5th December 2014

Application P/105/14

**Extension to Agricultural Building and Demolition of Agricultural Store
Sefter Farm, Pagham Road, Pagham, W Sussex, PO21 3PX**

Proposed
Relocated Retaining Wall Details
September 2014
6807b-104
1:500, 1:20@A3

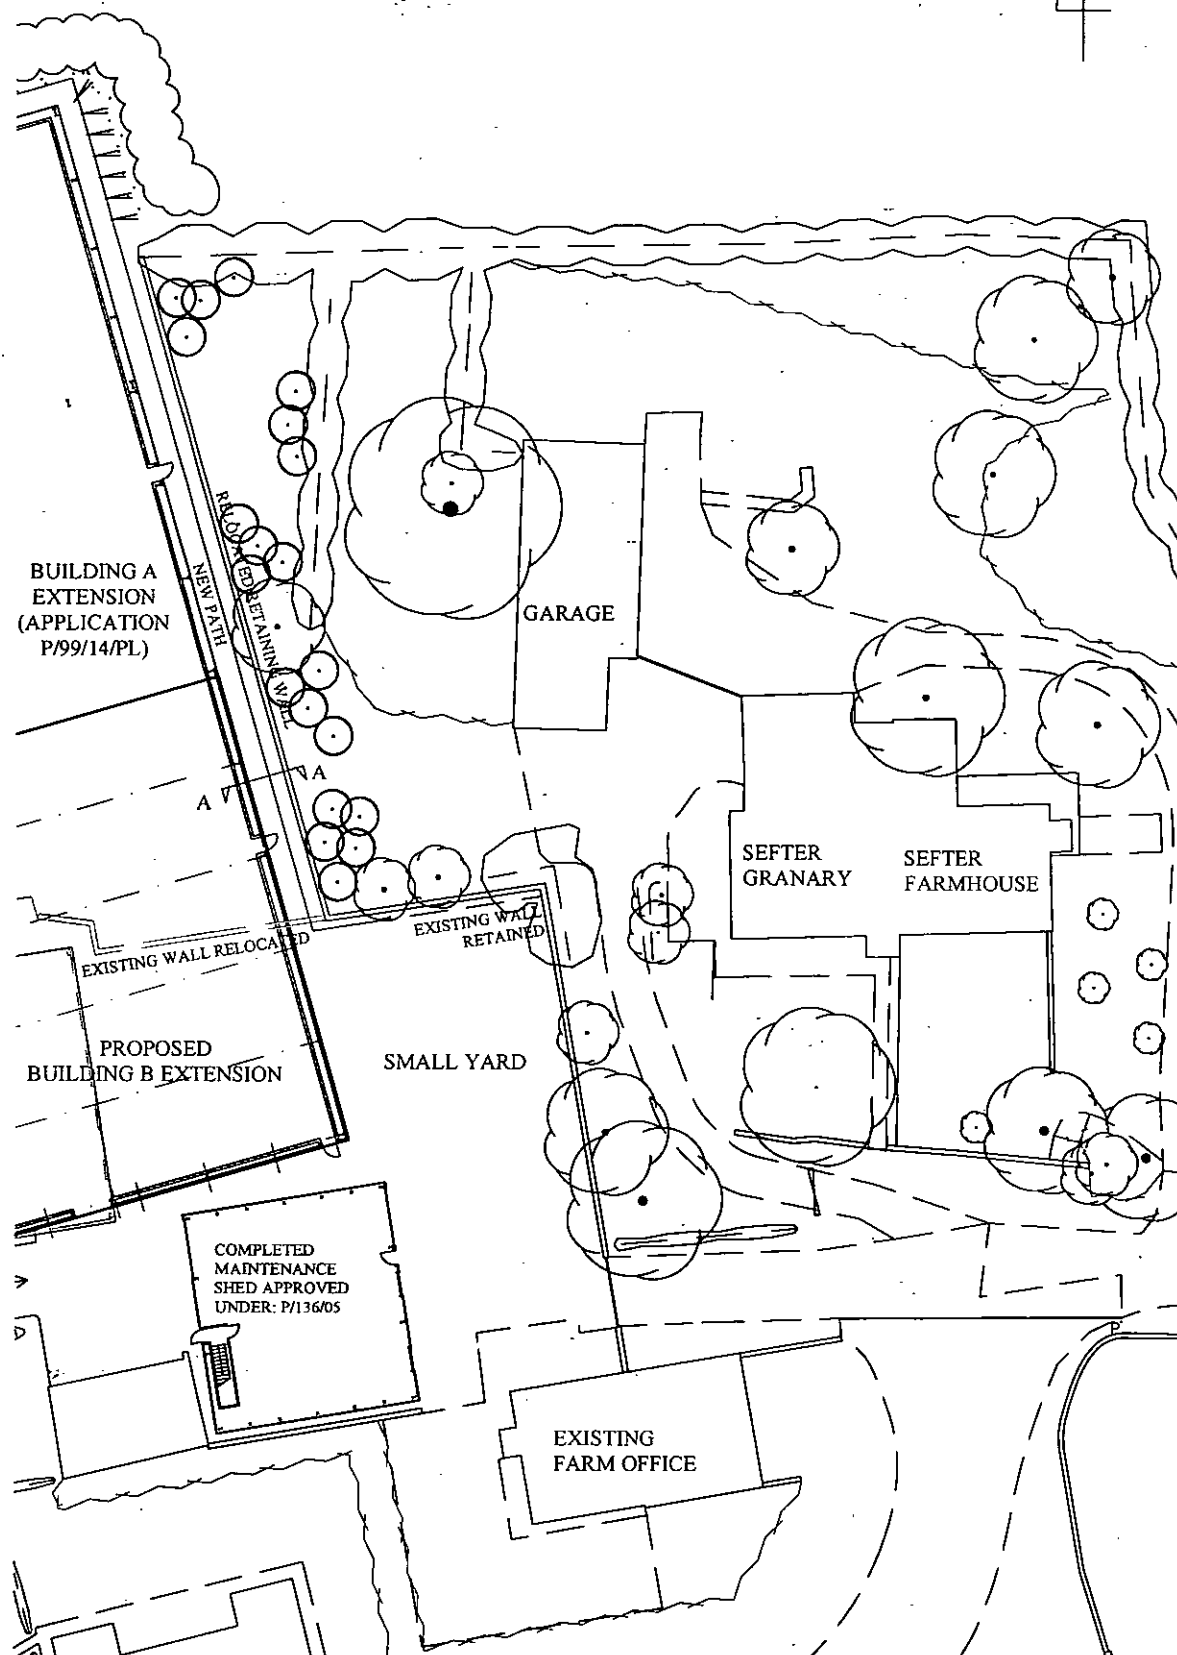
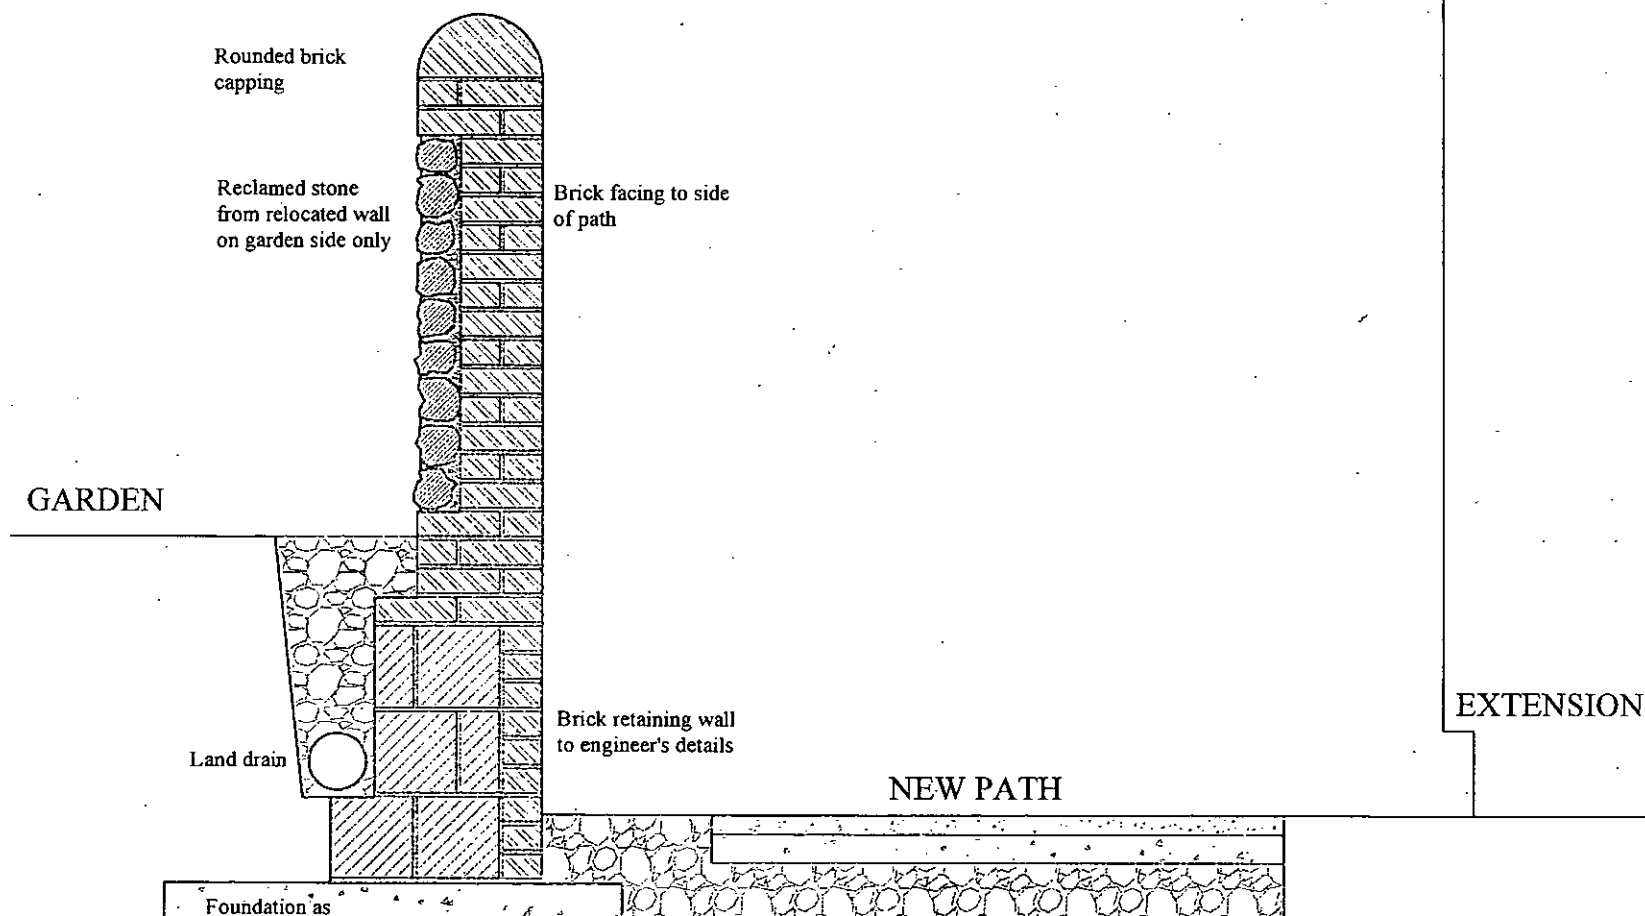
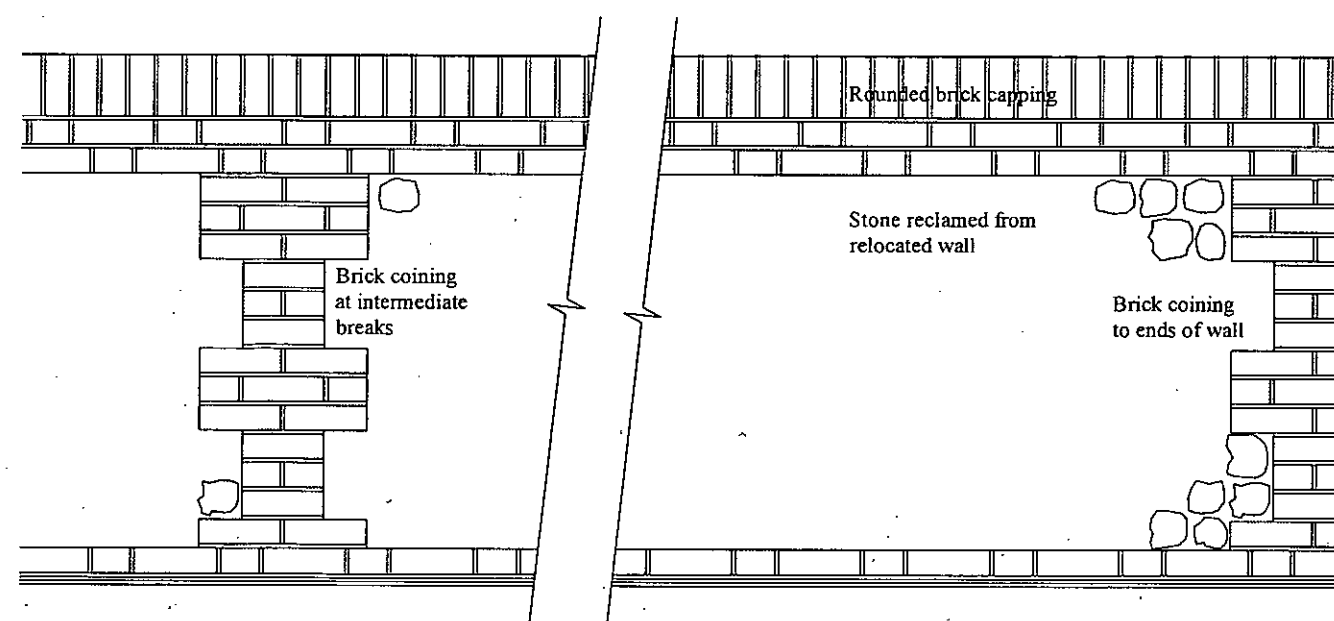
The applicant is very pleased to take up your suggestion to look at paragraph 137 of the NPPF for guidance in repairing the existing historic wall around the parking area, using stone recovered from the removed section of wall as the car park is used by visitors to the applicant's business and this would assist in the appreciation of the heritage asset, remove unsightly repairs and overcoating with cement render.

Proposed
Site Block Plan
July 2007
6807b-101E
1:500@A3

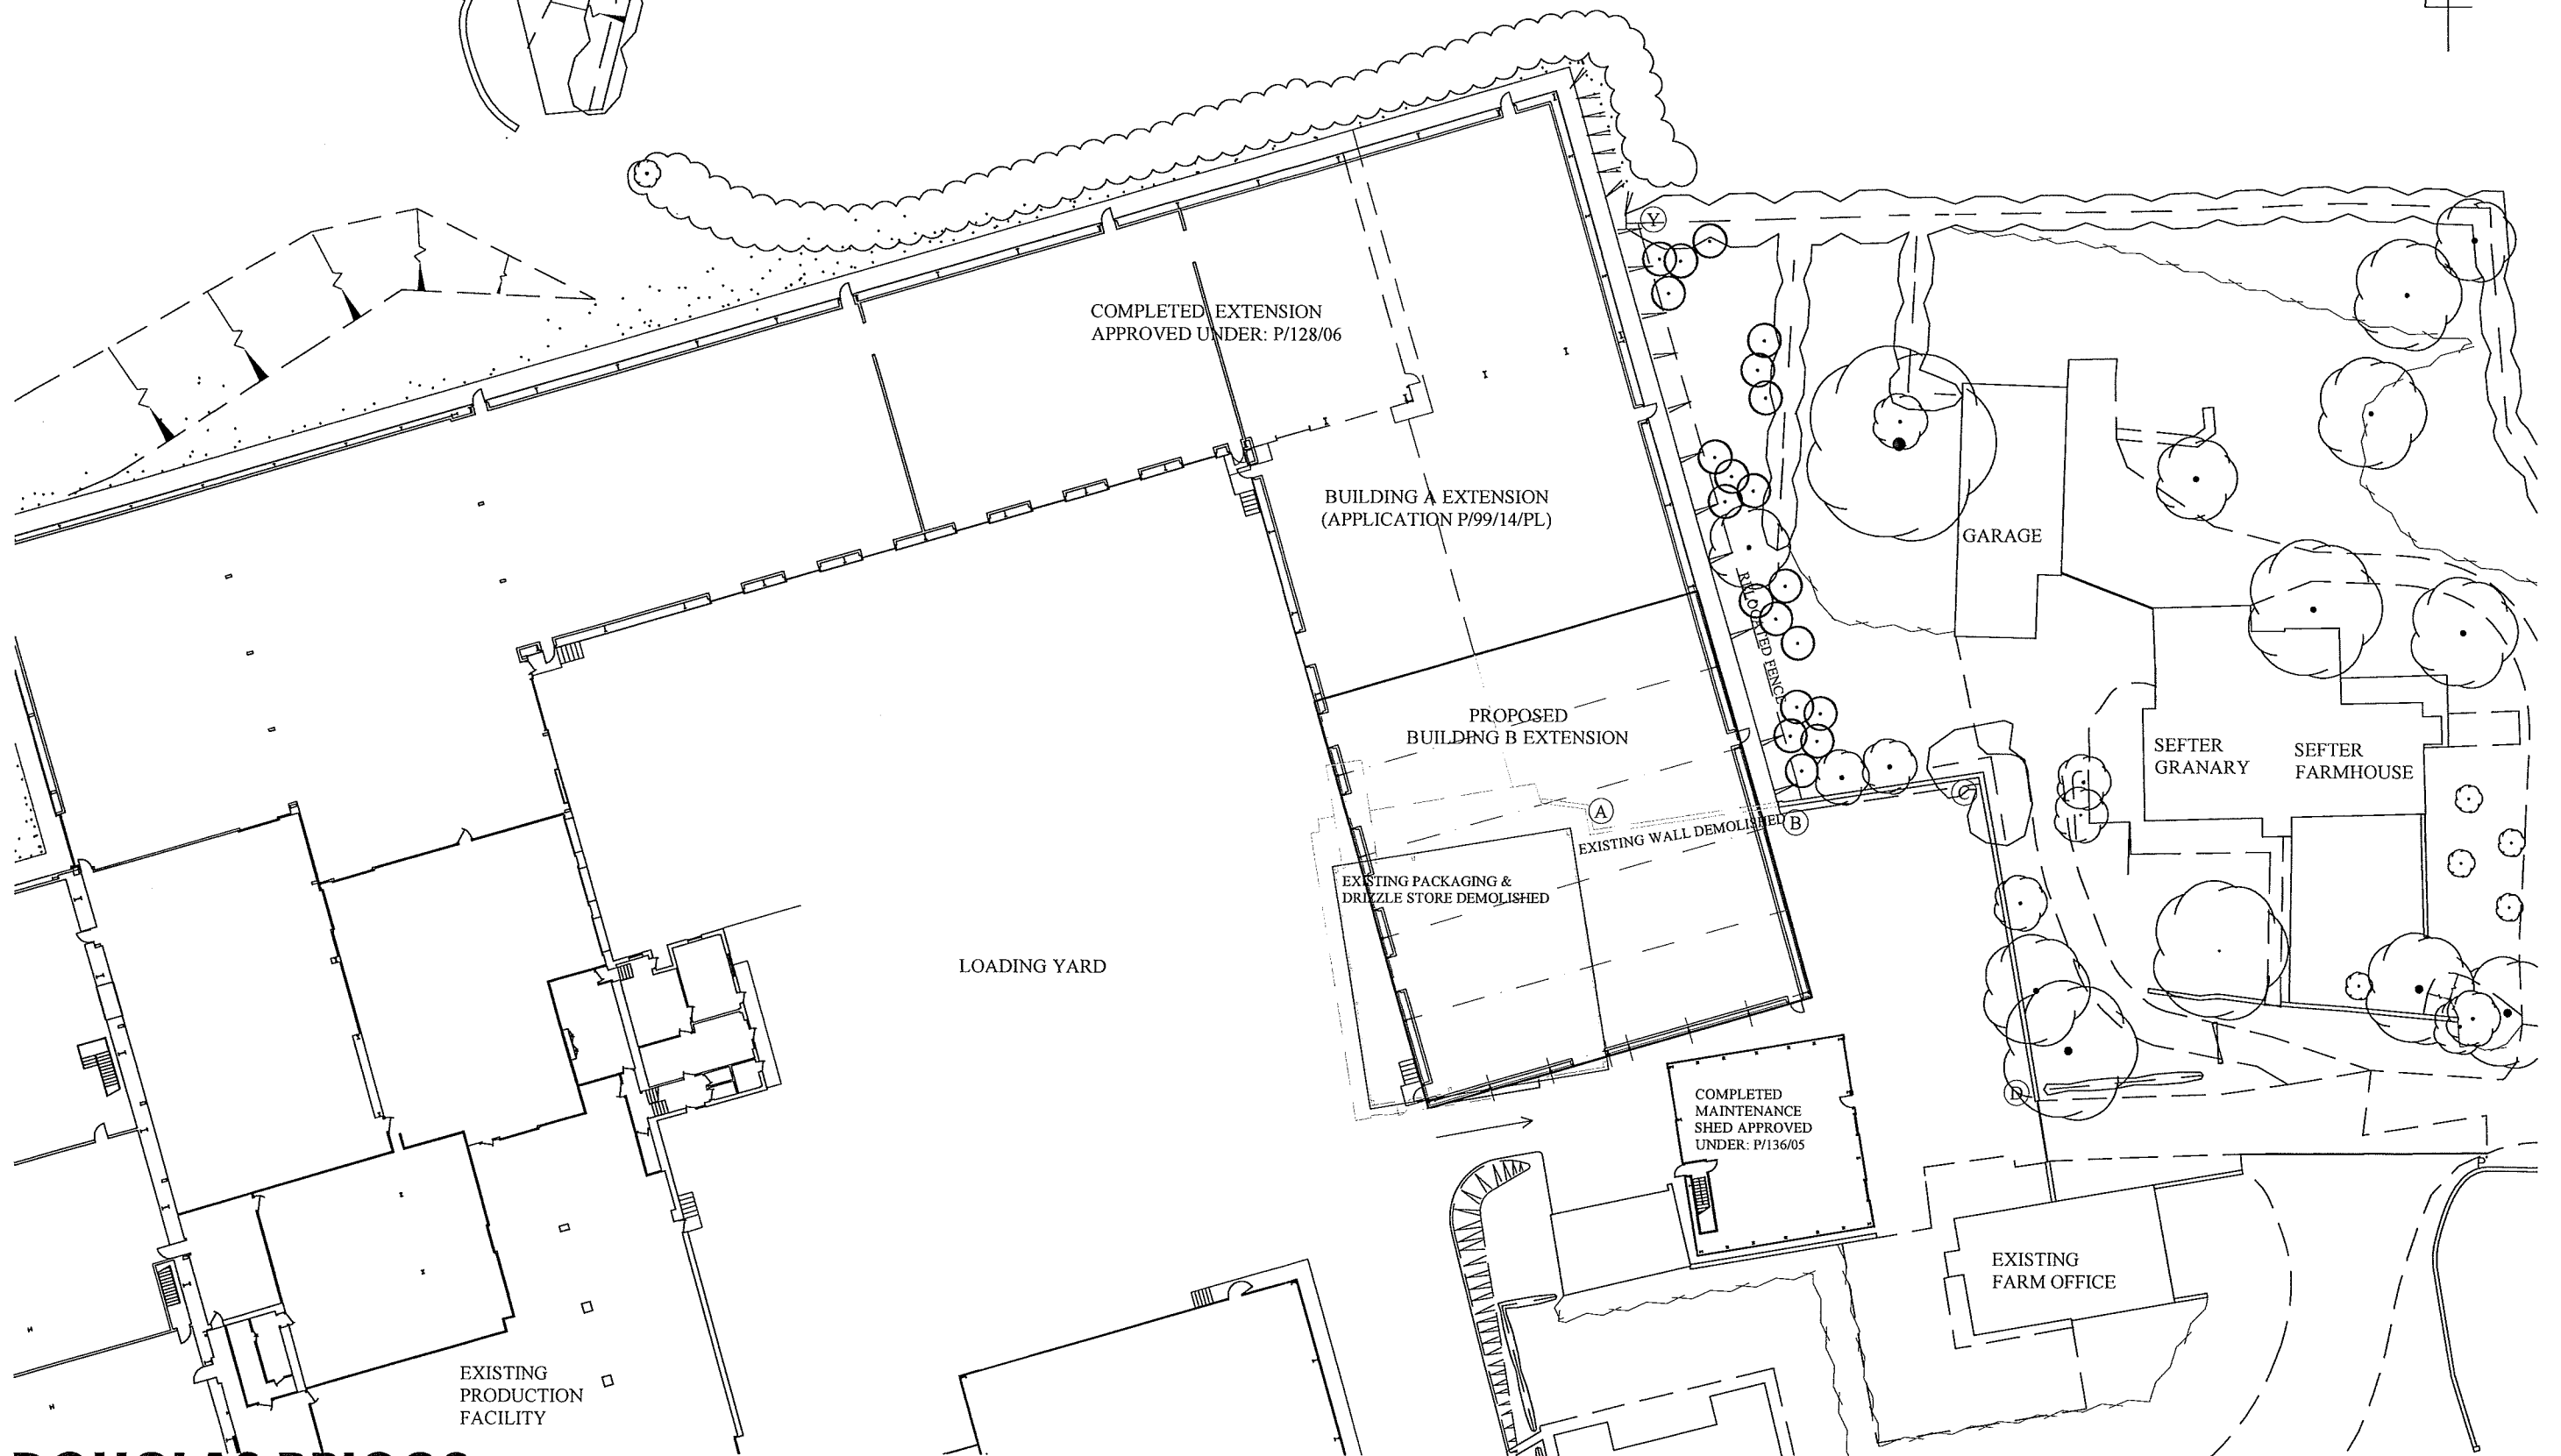
Barfoot's proposals have been careful to protect the wall along the historic cartilage of the Farmhouse, including the lengths of wall from B to C and C to D indicated on the attached drawing 101E, that unquestionably form part of the cartilage of the heritage asset.

The wall from B to C and C to D on drawing 101E have unsympathetic brick repairs and cement overcoating, it is proposed that these are removed and replaced with stone and brick recovered from parts of the existing wall A to B to be removed.

The resources first directed into the wall from B to Y have been diverted into the parts that can be most easily appreciated by the public visitor and the boundary from B to Y will allow for a graded bank to retain the existing ground level of the garden and repositioning of the existing close boarded fence as indicated.
